Please ask for: Mrs D Johnson
Email: daun.johnson@arun.gov.uk
Telephone: 01903 737762
Our Ref: Y/152/20/RES
Your Ref:
Date: 12th January 2021

Application for Approval of Reserved Matters Following Outline Approval

Development: Approval of reserved matters (appearance, landscaping, layout and scale) following the grant of Y/91/17/OUT for 250 No. dwellings with associated parking, road/footway/ cycleway provision, open space, landscaping, surface water attenuation & ancillary works.

Location: Land At Bilsham Road Yapton

CLIENT:	Bilsham Road Development LLP	PROJECT:	Bilsham Road Yapton
SCALE:	1:100 (A1 ORIGINAL)	DRAWING:	C3H10 - Semi Full Plans & Elevations
DRAWN:	RDB/SA	19284	P127
DATE:	01/09/20		A

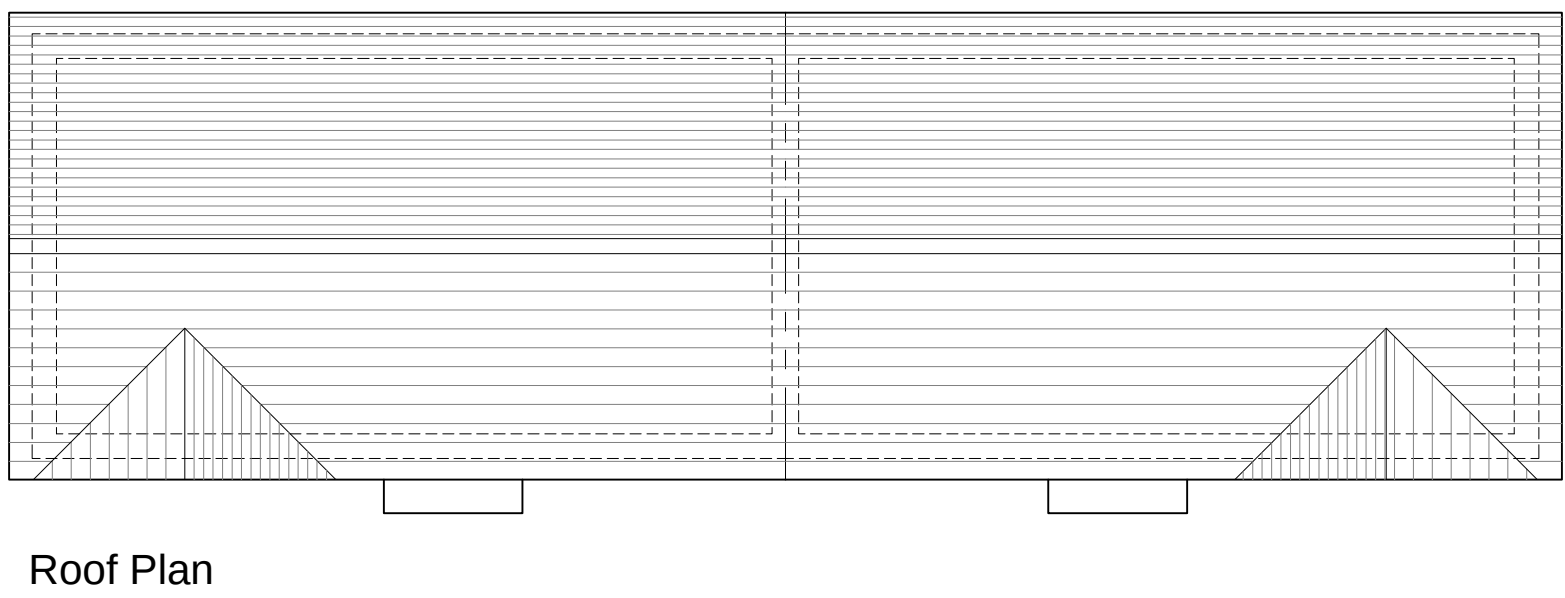
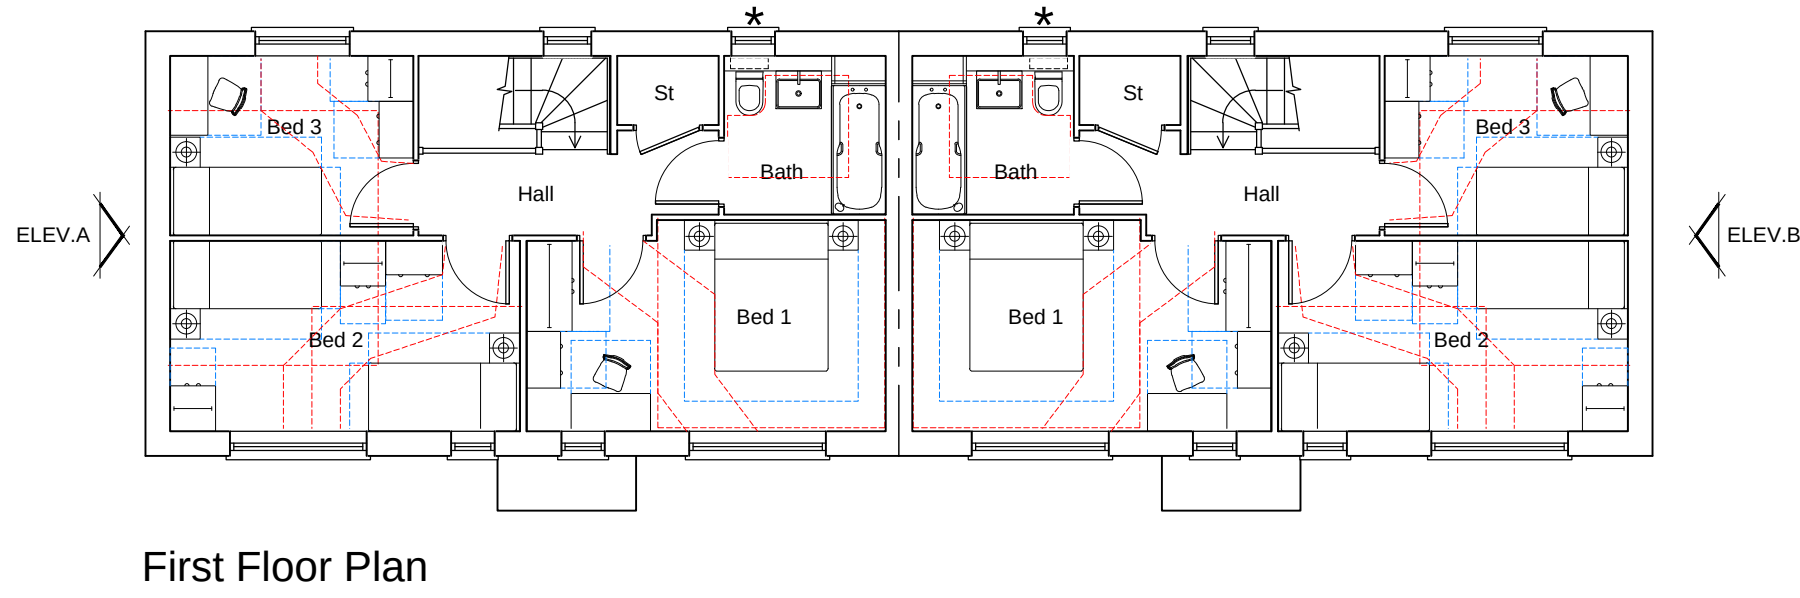
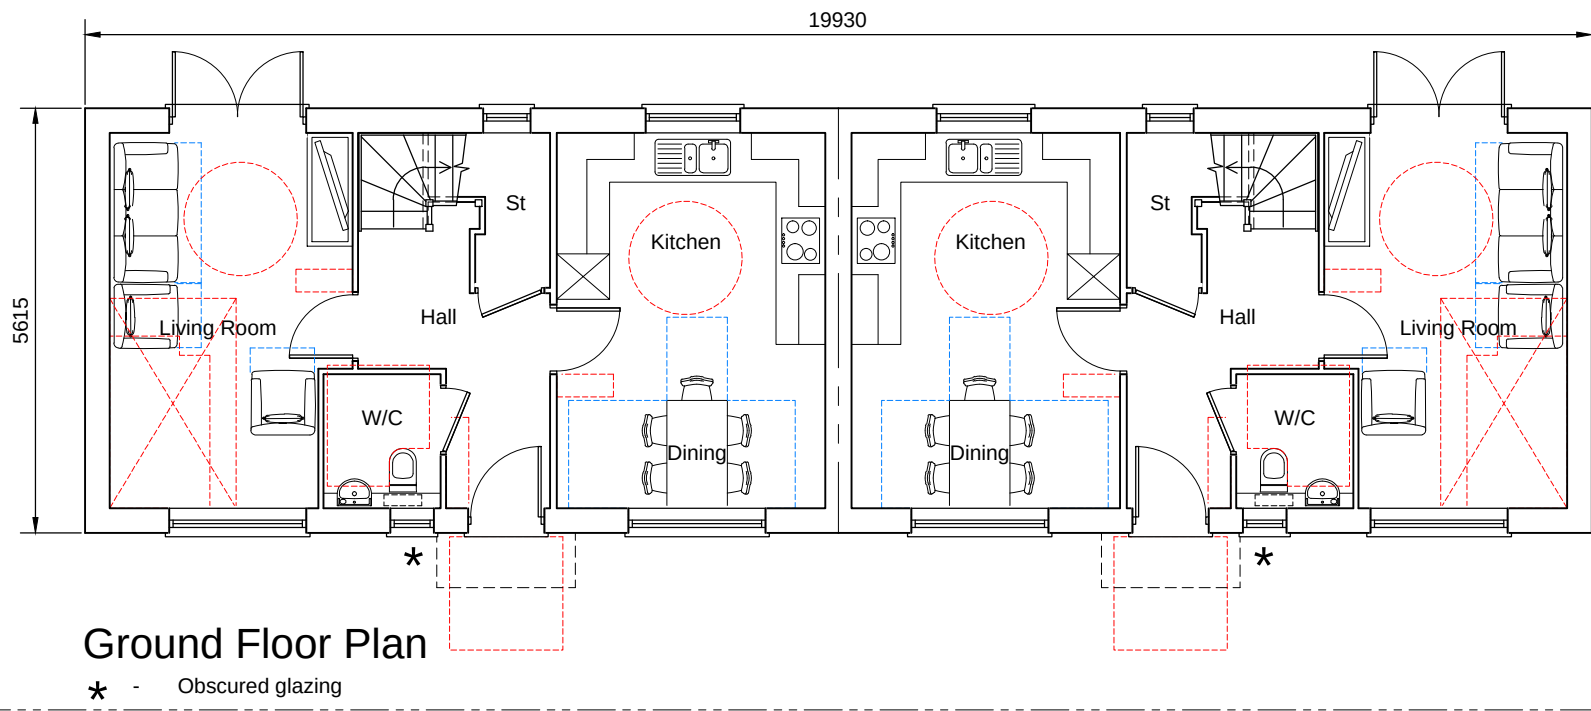
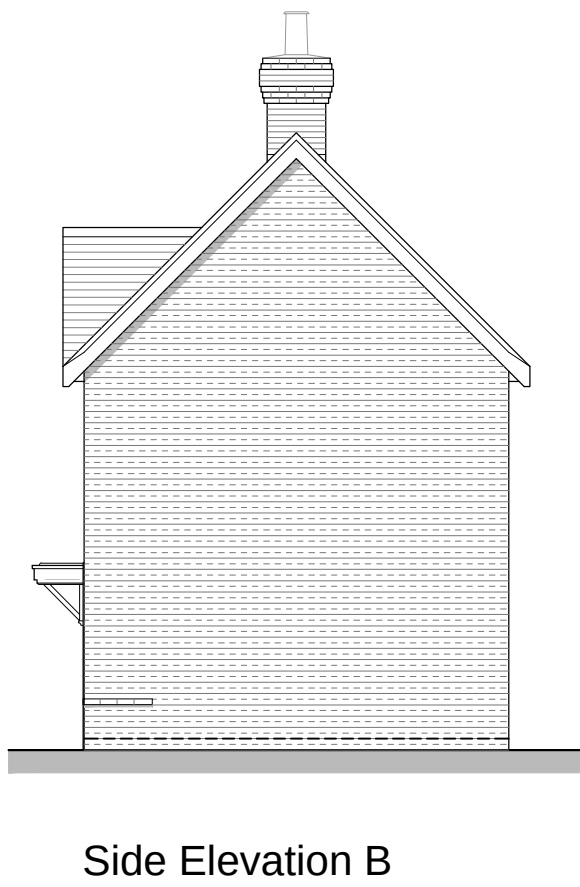
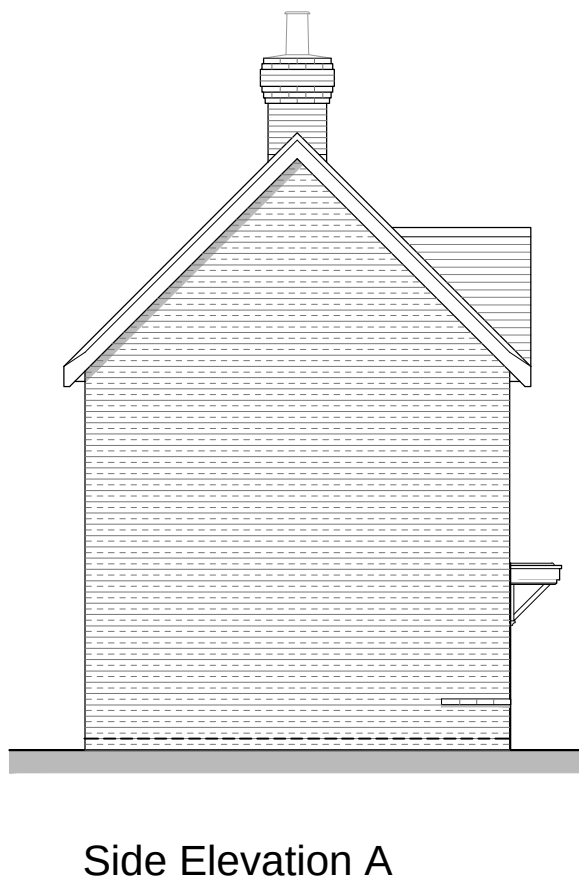
On Plan P127 the ground floor plan and rear elevations do not accord. Please amend accordingly.

CLIENT:	Bilsham Road Development LLP	PROJECT:	Bilsham Road Yapton
SCALE:	1:100 (A1 ORIGINAL)	DRAWING:	3B5P Type B - Semi Elevations
DRAWN:	GE	19284	P141
DATE:	01/09/20		A

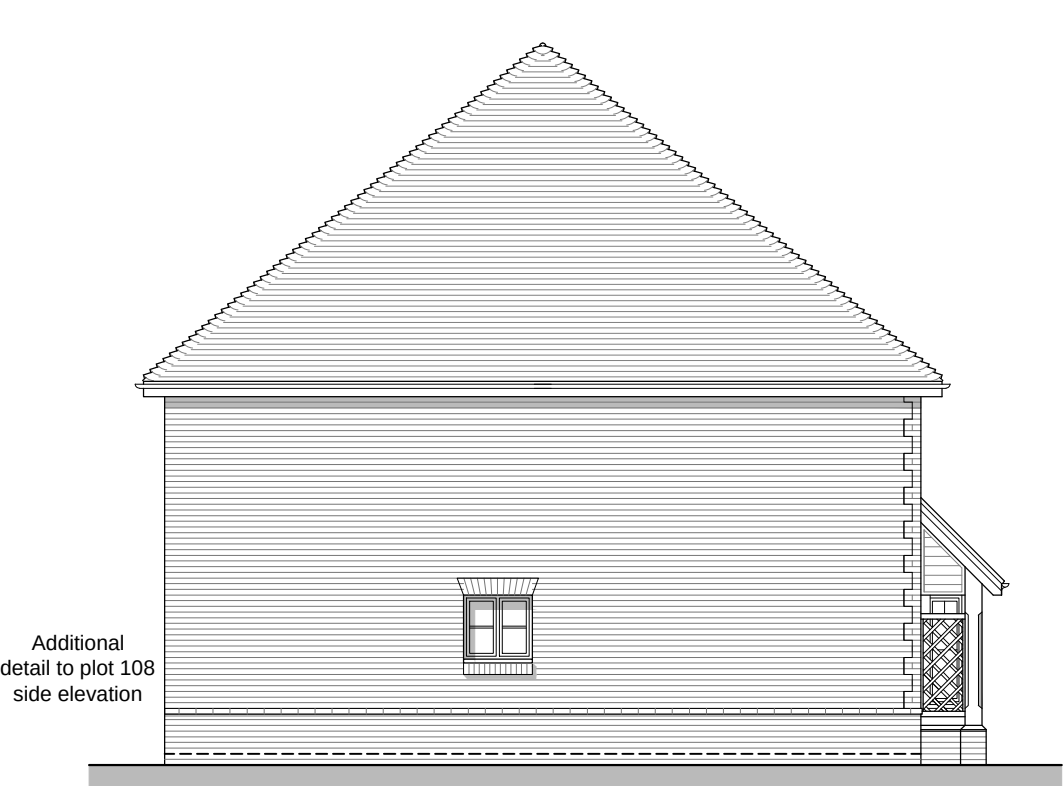
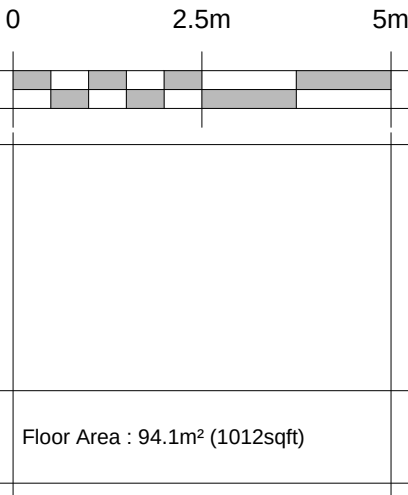
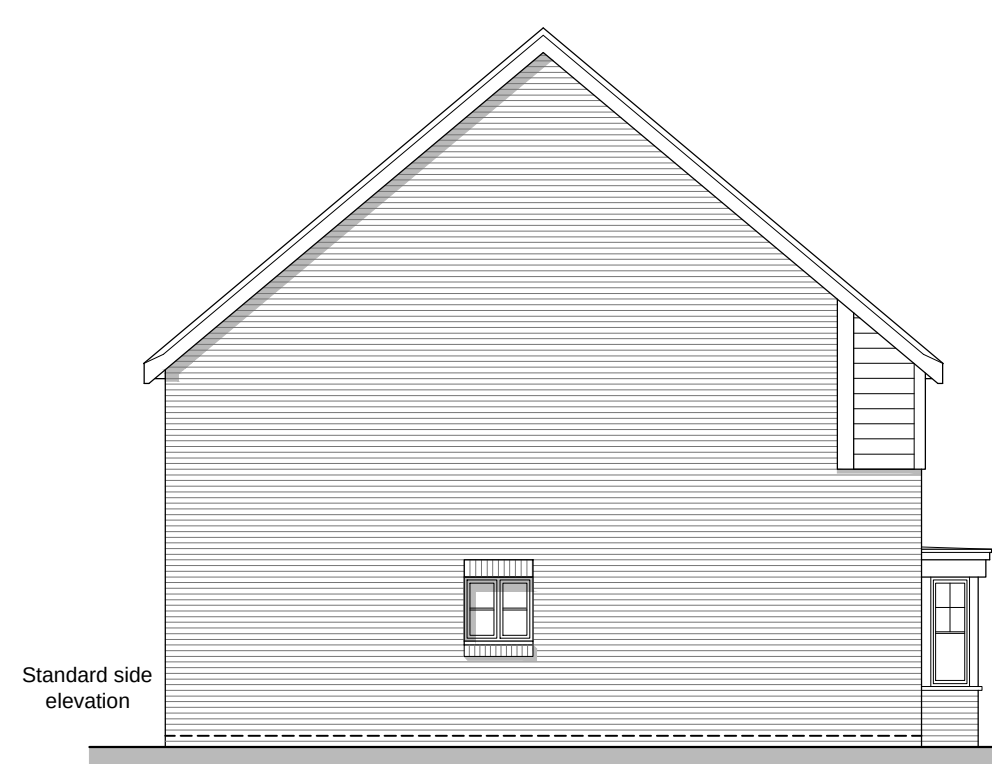
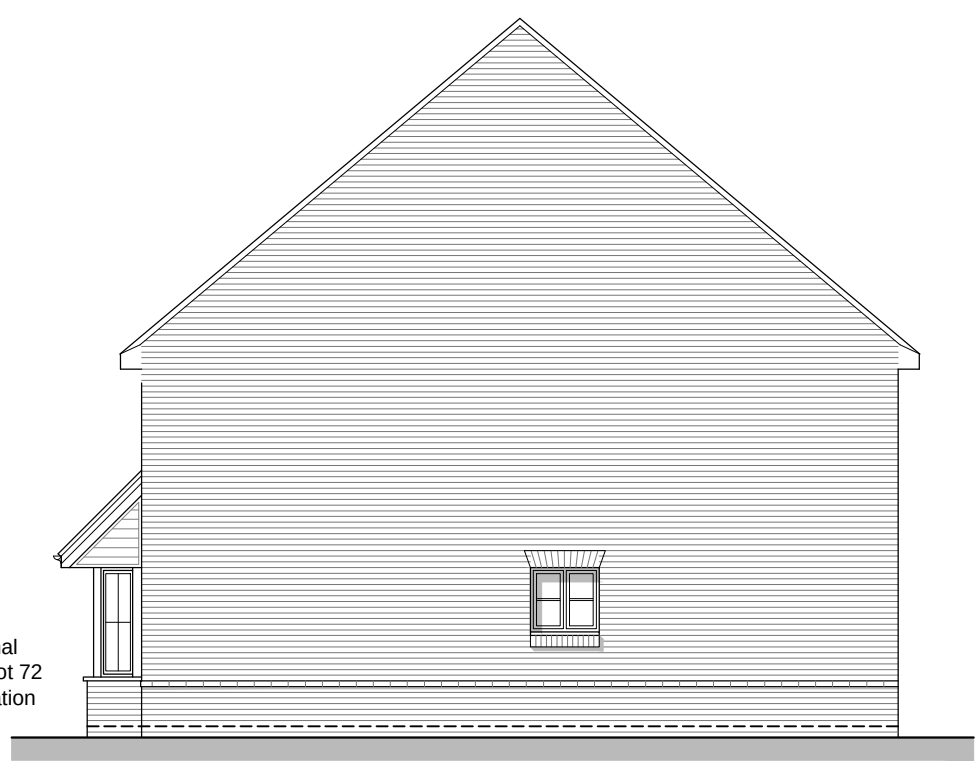
On Plan 141A (Lovey's) the ground floor plan and front elevation do not accord. Please amend accordingly.
